Application No: WA/57/20/HH
Site Address: 8 Prime Close Walberton BN18 0PL
Description of works: Extension to roof and loft conversion

Thank you for your internet representation made on 1st November 2020 which has been recorded as an objection with the comments as follows:

Project : Roof Extension  
Title : Elevations  
Drawing N.O : PL CC 0101 / 2020

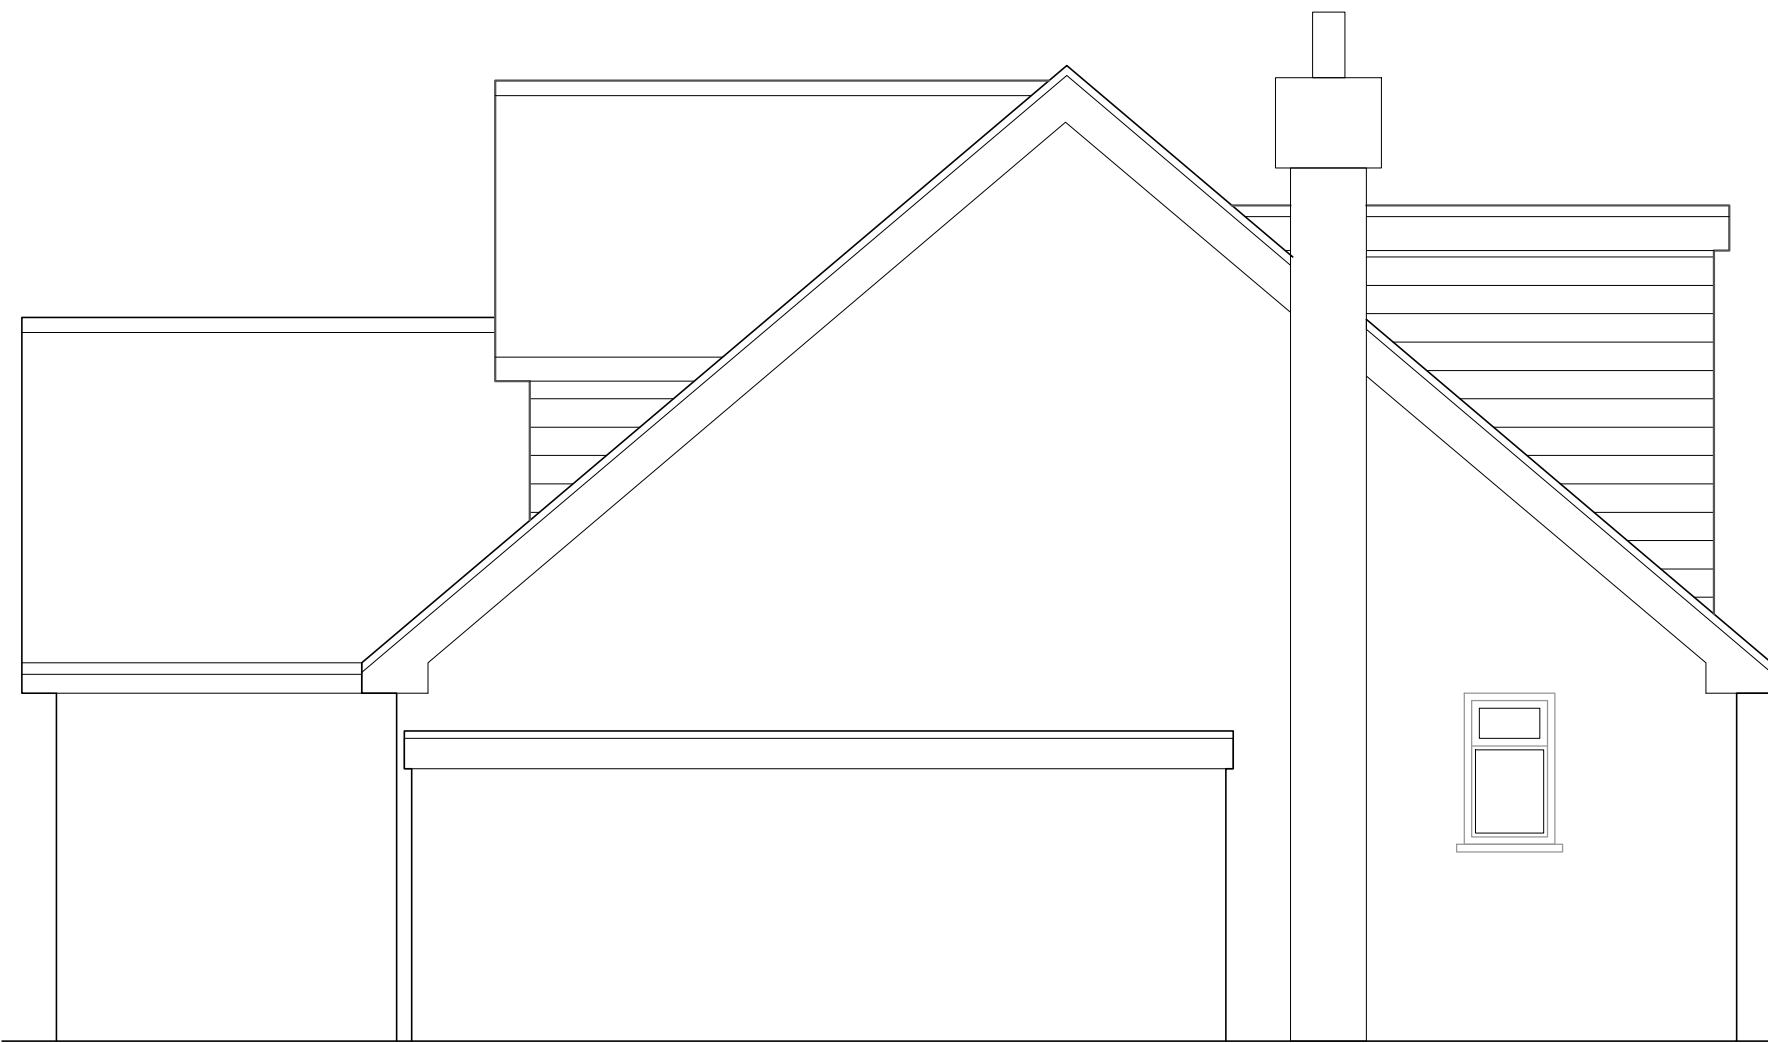
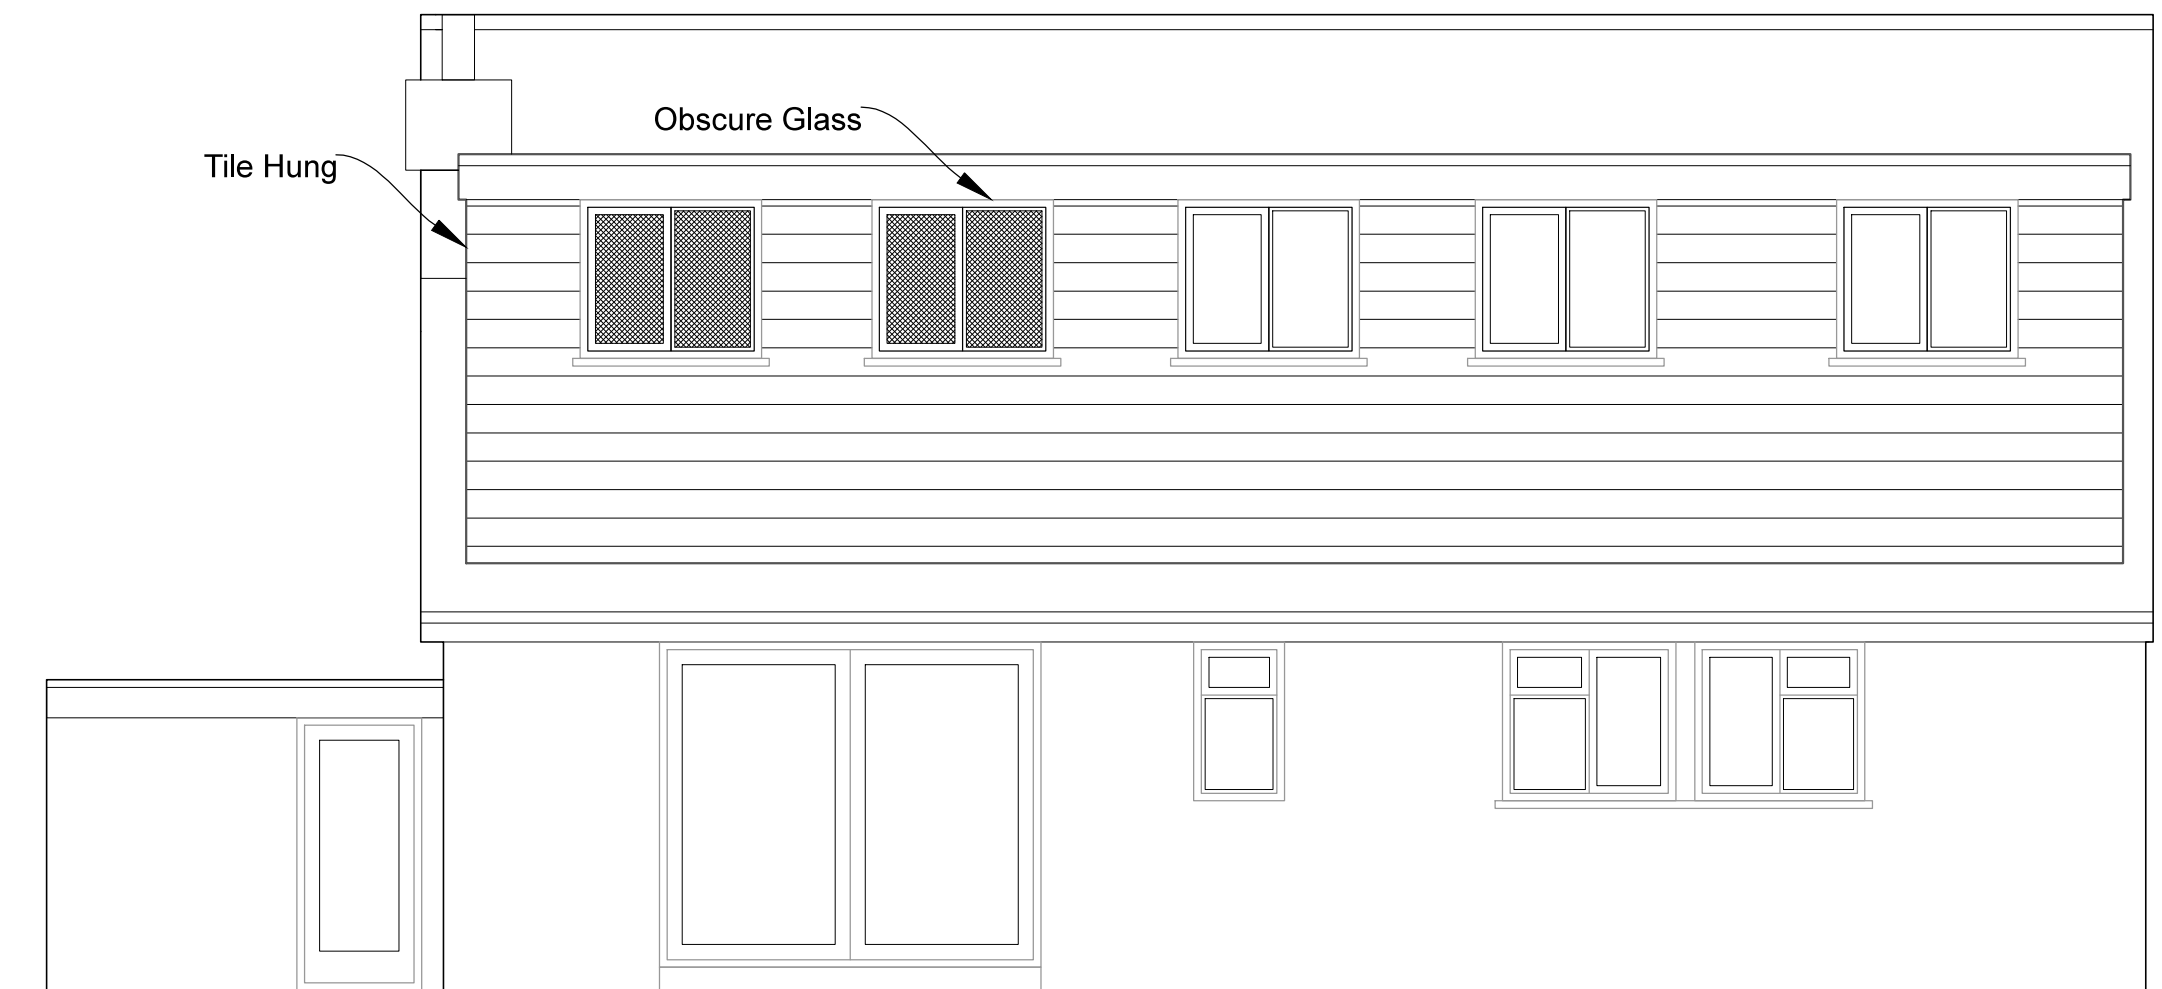
I object to the application because it does not comply with Planning Guidance for roof conversions - "No extension beyond the plane of the existing roof slope of the principal elevation that fronts the highway"

The proposed dormer facing onto Prime Close does project beyond the roof plane and thus contravenes legislation.

Further if permitted it would set a precedence in the Henry and Prime Close area, a homogeneous and well managed environment where there are no examples of dormers projecting beyond the roof plane facing onto the highway.
